From: [REDACTED]
Sent: 31 January 2019 17:01
To: Anita Gardner
Subject: Objection to planning application EP/185/18/PL

Objection to Application ref: EP/185/18/PL

Site: Land rear of Beechlands Cottages, Beechlands Close, East Preston

Proposal: Demolition of existing buildings & erection of 3 No. dwellings with associated parking, alterations to existing access & relocation of staircase to flats (resubmission following EP/7/18/PL)

DRAWING TITLE
Proposed Floor Plans and Elevations

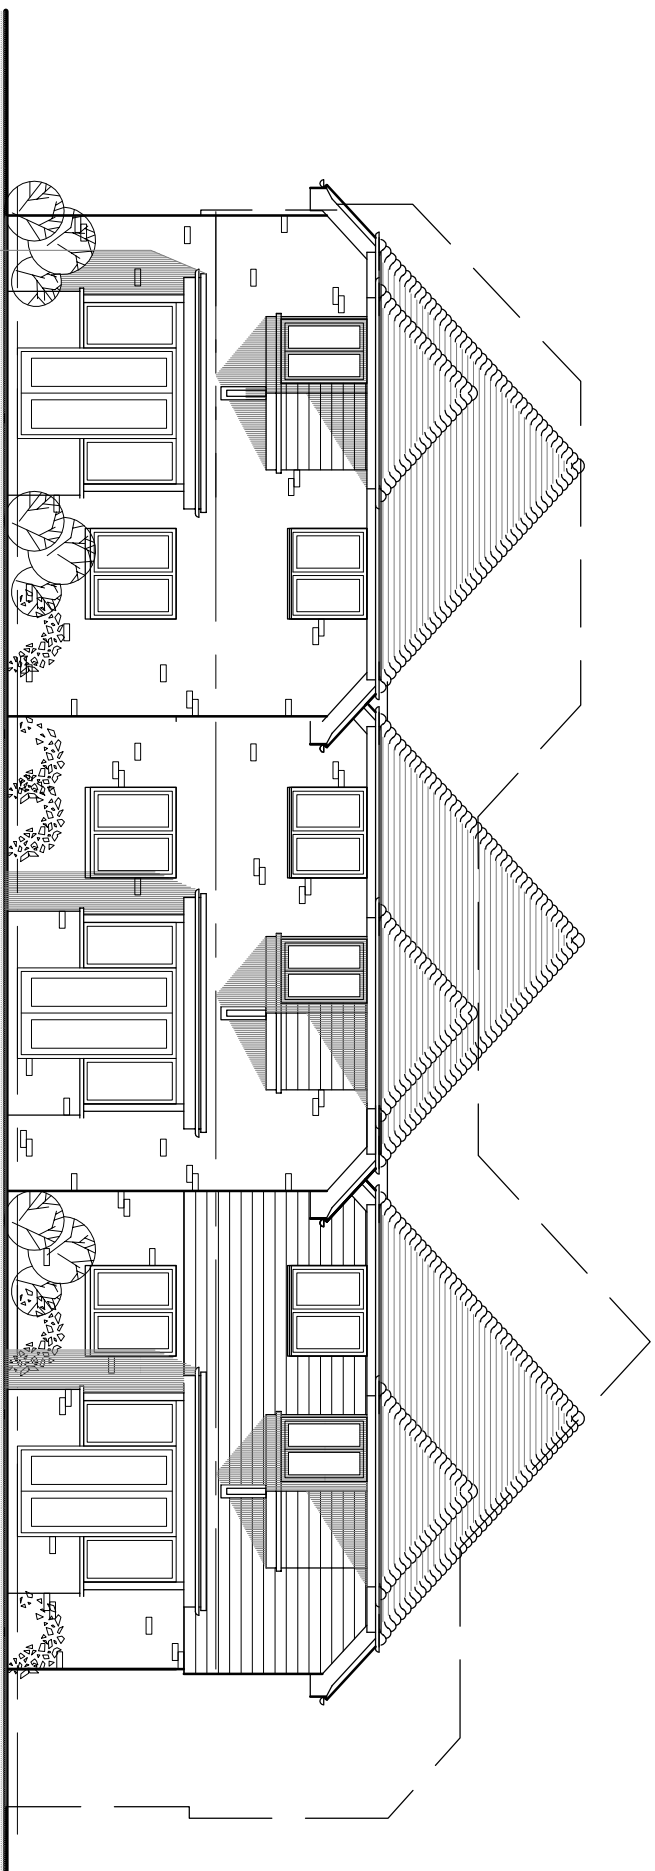
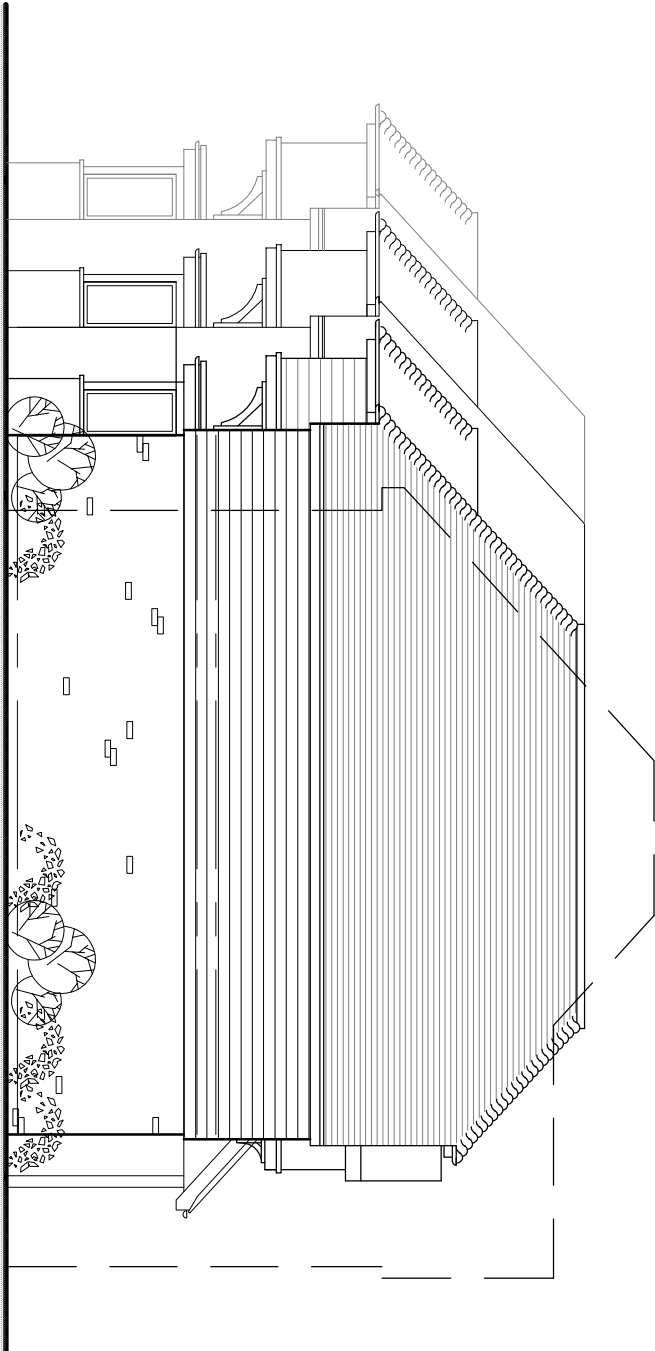
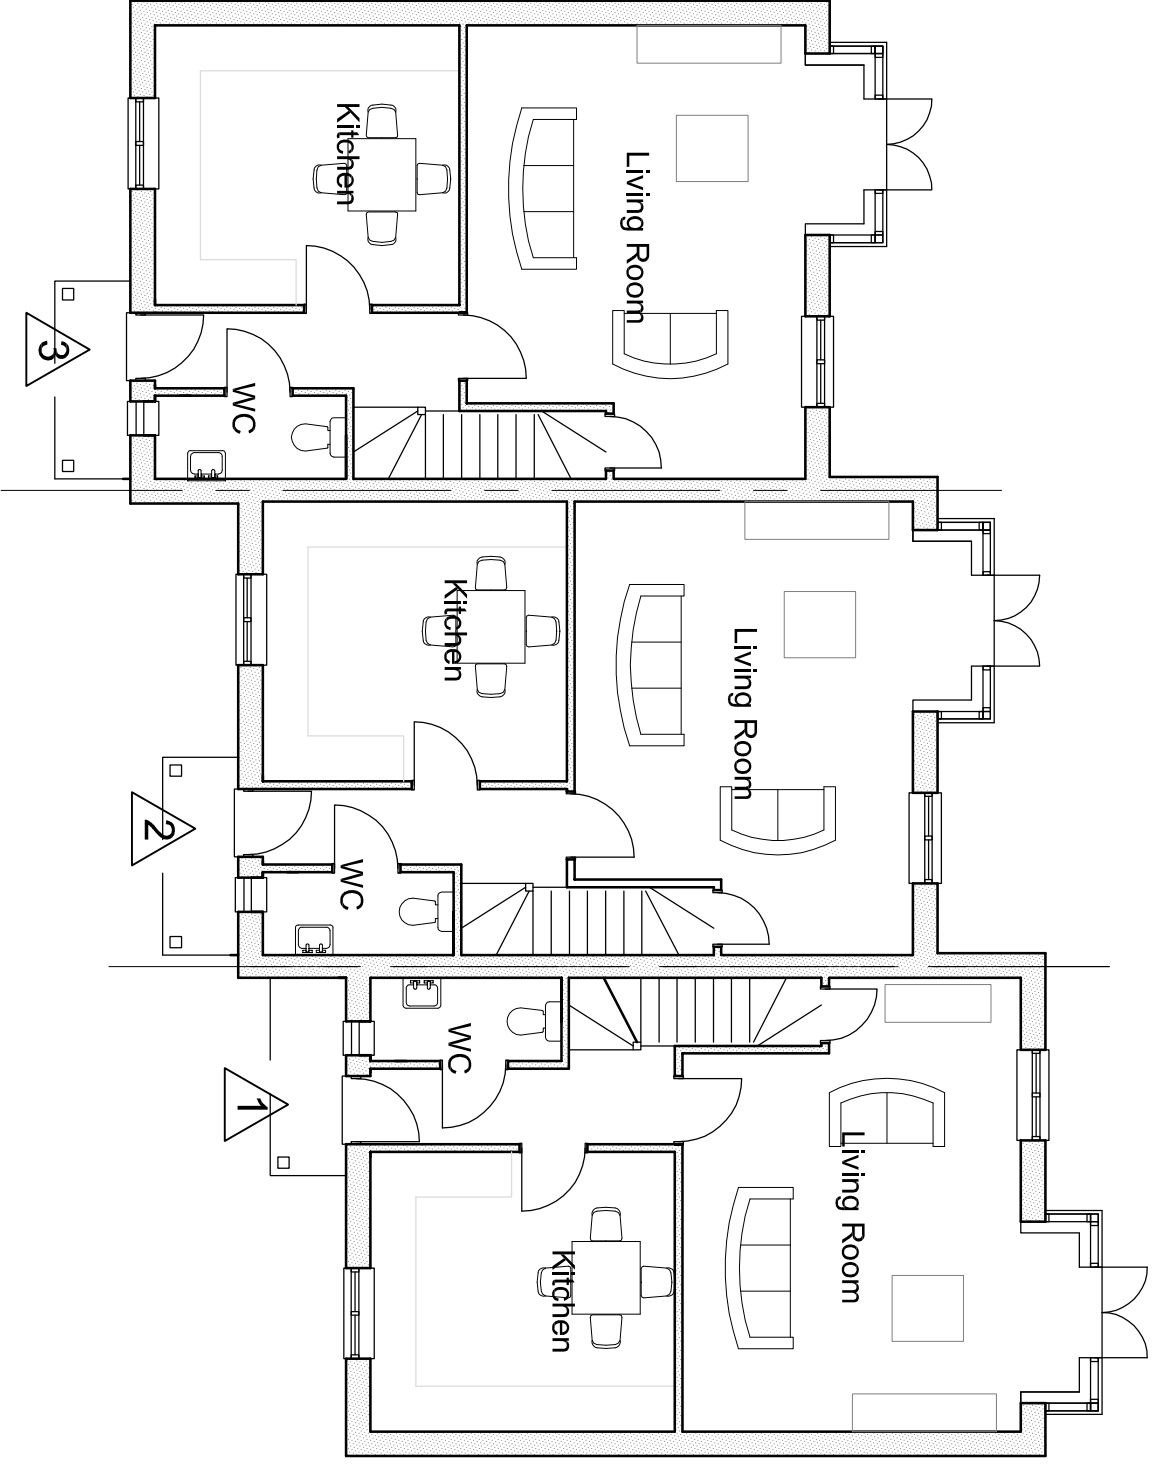
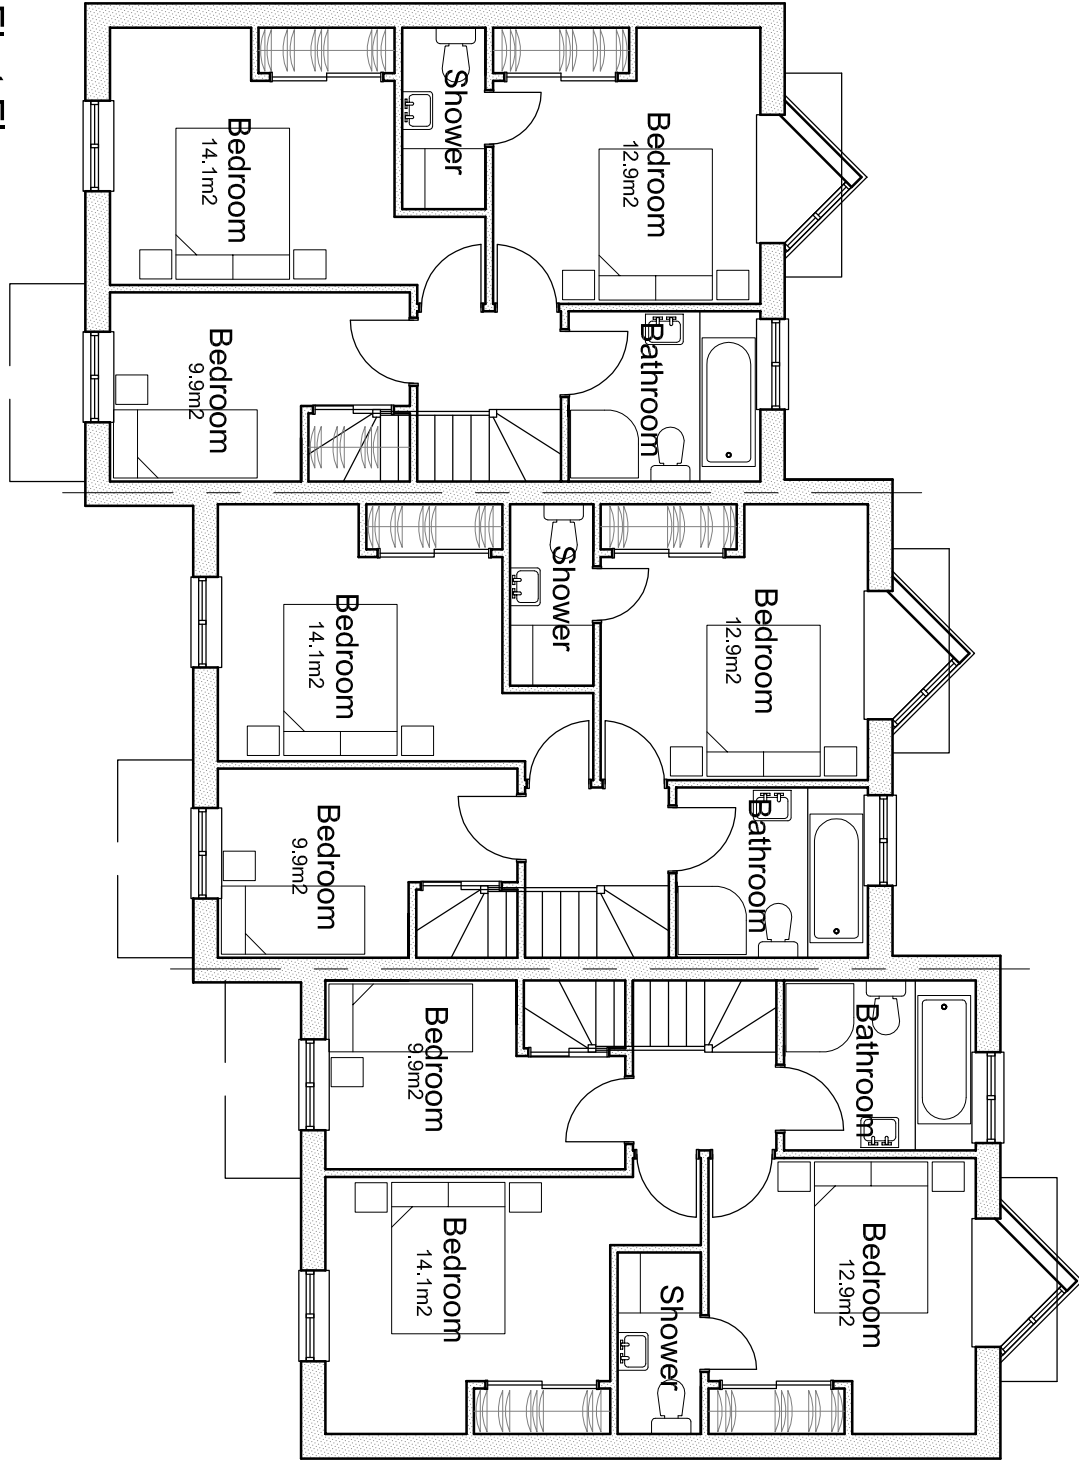
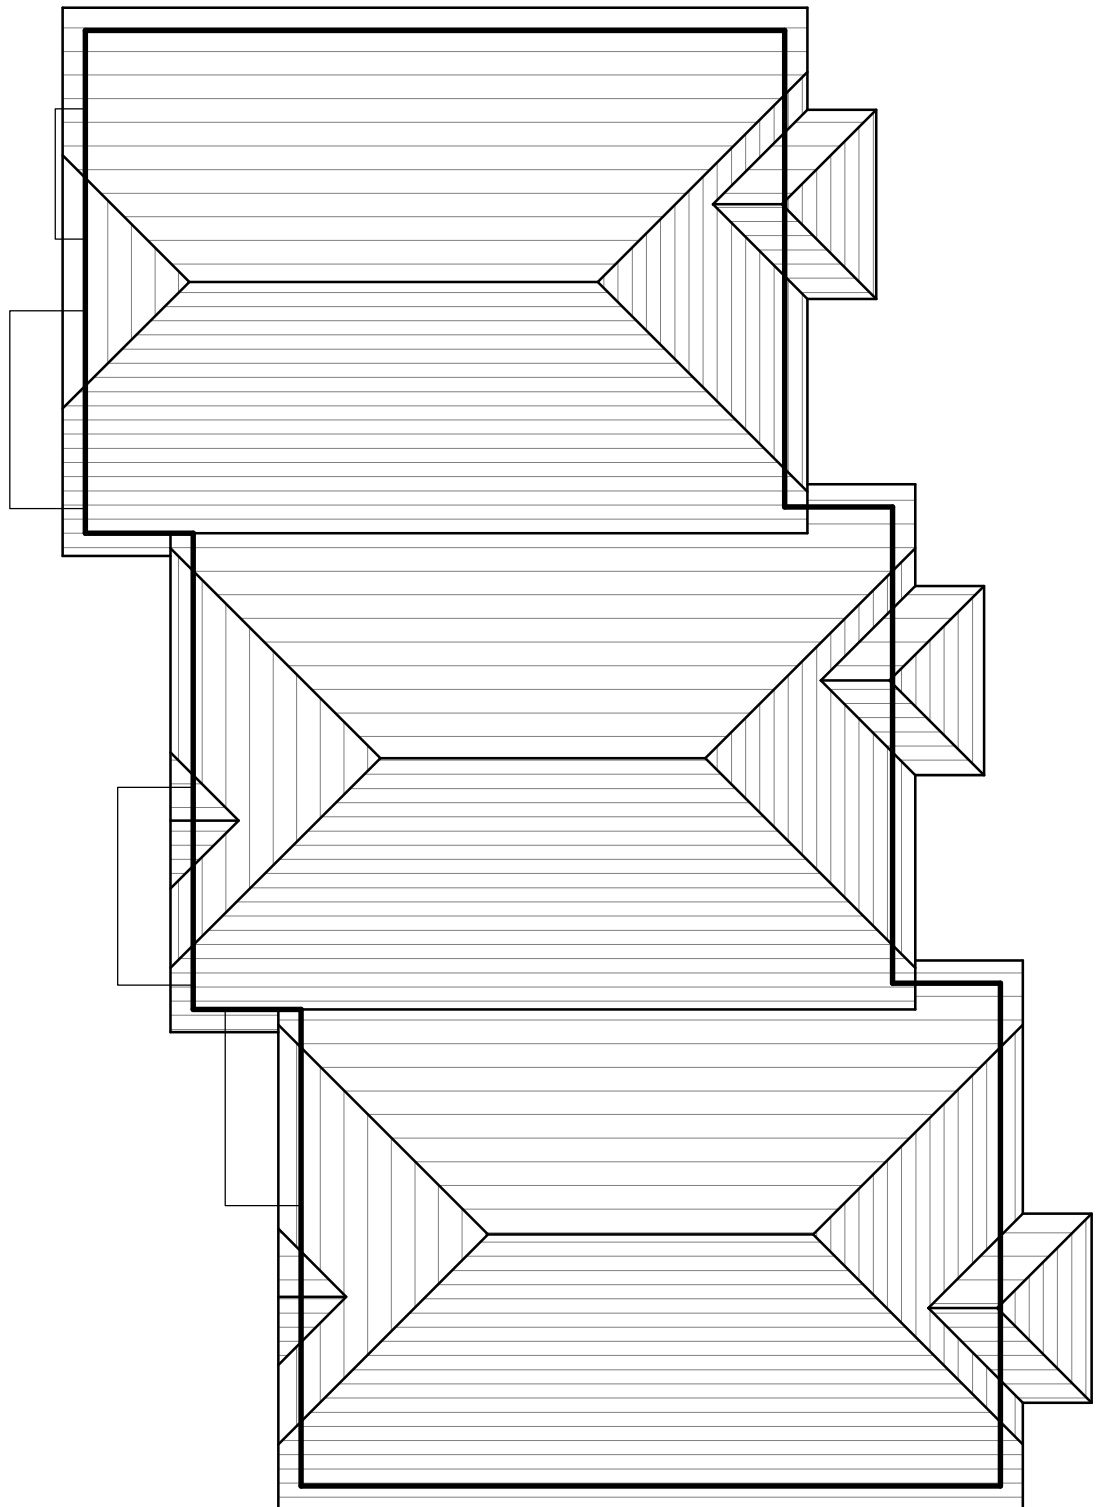
This existing situation would significantly change as a result of the proposed development with both a perceived level of overlooking and direct loss of amenity resulting due to the proximity of the terrace of three properties extending along a significant proportion of the southern boundary of our rear garden. It is accepted that a planning permission does exist for a similar scale of development on the site, however, this relates to a scheme that resulted in dwellings being positioned further from our garden area at No. 125 North Lane to that now proposed.

The previous permission under EP/7/18/PL sited dwellings at least 10 metres from the shared boundary. Whilst we felt this was detrimental to us, this separation is not now achieved by any dwelling proposed,

having been almost halved with respect of the proposed Plot 1 and reduced by 1metre and 2metres for plots 2 and 3 respectively.

The significant change to the scheme, from that of the previous approval, would position three properties between 6.2metres – 9 metres from our garden. This being a staggered 2-storey terrace which would have a significant and bulky appearance when viewed from the rear garden and living spaces of our property at No.125 North Lane. The staggered nature would effectively enclose the rear garden of our property.

The revised design would therefore have an unacceptable impact upon our property due to its overbearing nature. It is not considered that the design tweaks and orientation of windows overcomes the substantial bulk and overbearing affects that will result.
